From: Claire Booth
Sent: 29 November 2012 09:38
To: Jane Tucker
Subject: Parish Response

From Bowland forest higher division parish council

Ref CONPC/3/2012/0980

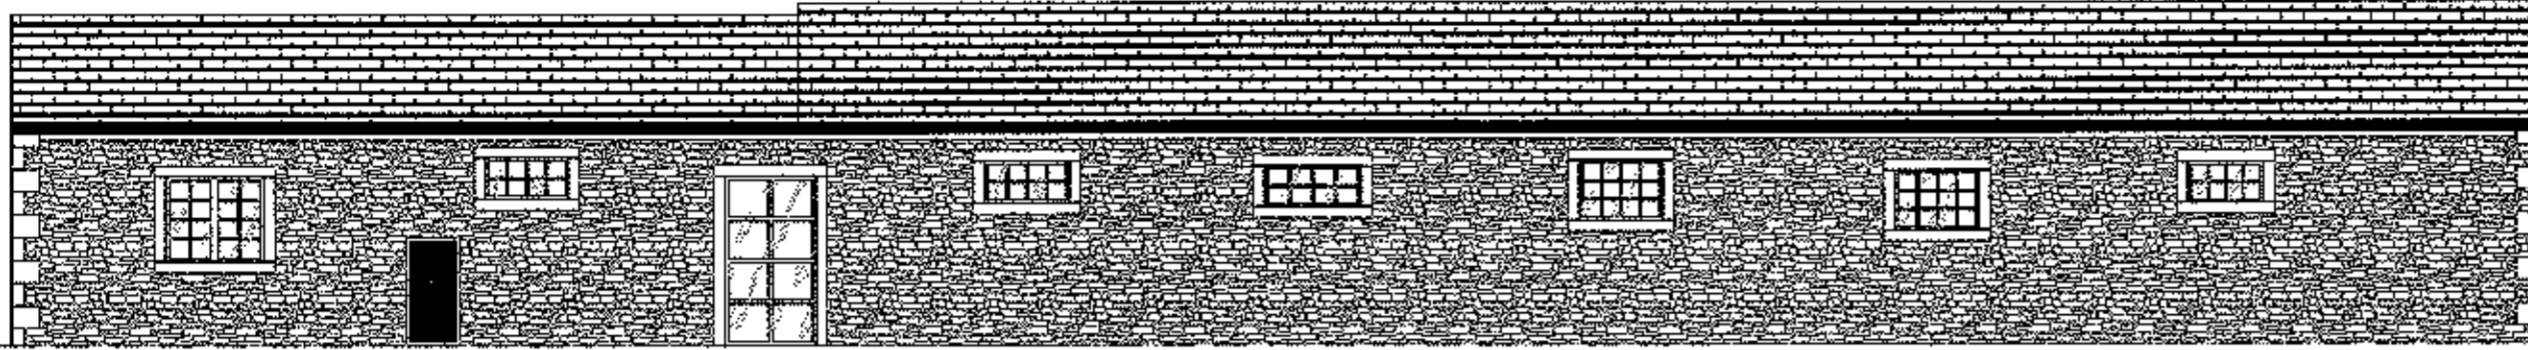
The parish council would like to comment that the properties only seem to have one door now whereas they had a rear fire exit before - perhaps a window doubles as a fire exit? Also they thought that the 3 bed property would have a second WC/ basin.
